## DECISION DELEGATED TO DEVELOPMENT MANAGER

**Application No:** H07-1040-19      **Applicant:** Mrs R Zdroba  
**Proposal:** Erection of double garage/store/shed (part retrospective)  
**Location:** 32 Hillgate Gedney Hill Spalding  
**Terminal Date:** 29th May 2020

Project:	Detached Garage
Client:	Rebeca Zdroba
Address:	32 Hillgate Gedney Hill Spalding PE12 0NN
Drawing Title:	Proposed Elevations
Drq No:	01
Scale:	1:100 @ A4
Date:	Mar 2020

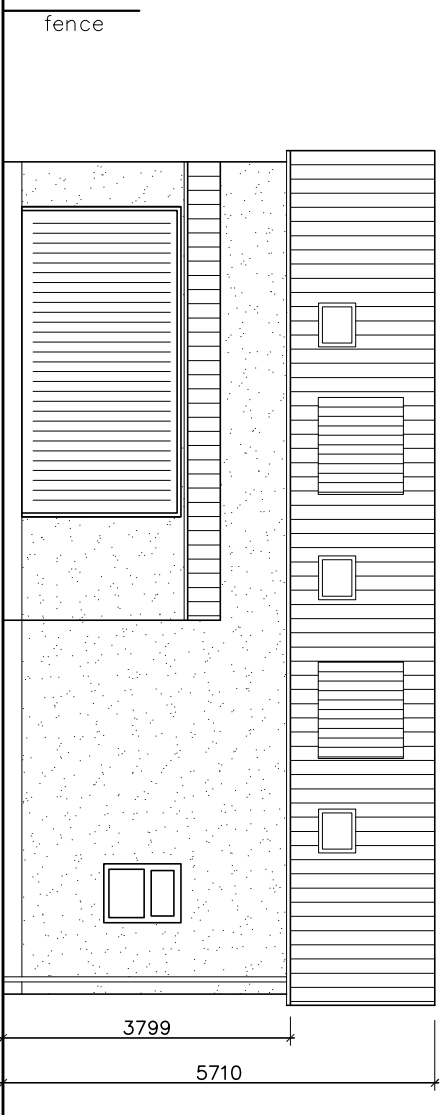
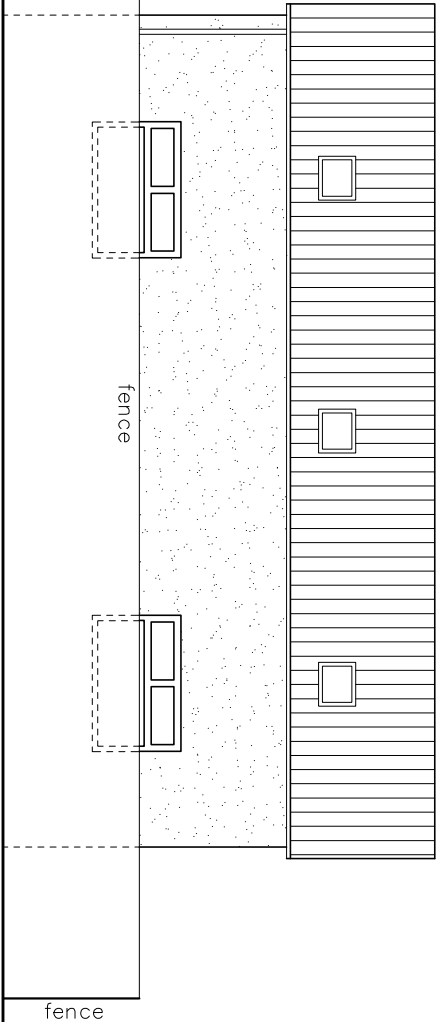
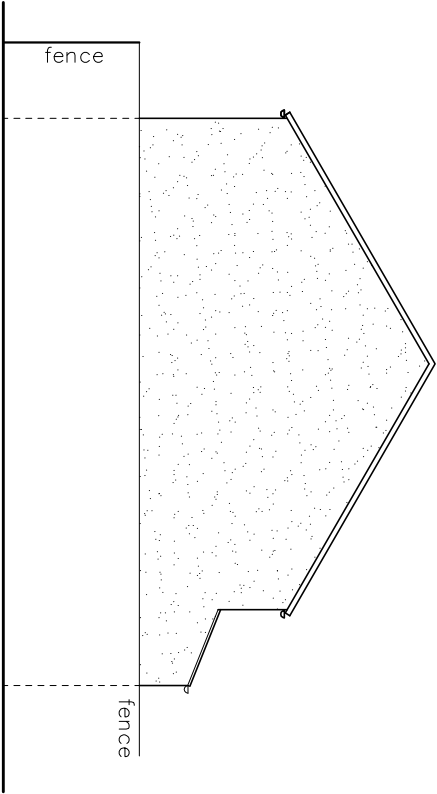
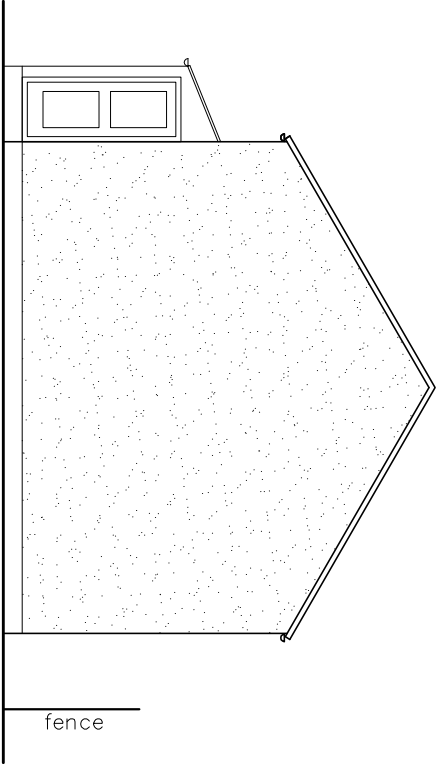
The proposed building would be one and a half storey with a ridged roof and accommodation within the roof space. It would set back behind the main house the subject of planning permission ref. H07-1162-17 and also behind the position of the dwelling unlawfully commenced on site. It would have a ridge height of some 5.71 metres. Despite its height, it would be subservient to the main house, which would have a ridge height of approximately 7.8 metres.

The approved dwelling is of traditional design. Although the proposed building is rather utilitarian its form is nevertheless not dissimilar to traditional outbuildings within the area, including a ridged roof. The roof form originally proposed did not reflect traditional vernacular. There are several other properties within the vicinity that have outbuildings/garages situated in a similar position at the rear. The building would be positioned further back than the former Red Lion Public House (grade II listed) in terms of its relationship. There are also existing backland dwellings within the immediate vicinity, including no. 26 Hillgate and 4 Station Road. Taking these factors into consideration and the general character of the area it is considered that the building would not materially harm the character/appearance of the locality or affect the setting of the former Red Lion public house.

In terms of external finish, the applicant has proposed green. Existing buildings within the vicinity are predominantly brickwork or a white finish. Notwithstanding the submitted details it is considered that the building should be finished in white or cream to be sympathetic with existing development.

The proposed building is one and a half storey and includes accommodation within the roof. Roof lights are proposed at the front and rear. However, the building is some distance from neighbouring property and would be approximately 21 metres from the rear of the former Red Lion public house. It is considered that the amenity of nearby residents would not be materially harmed in terms of overlooking, lack of privacy and overshadowing.
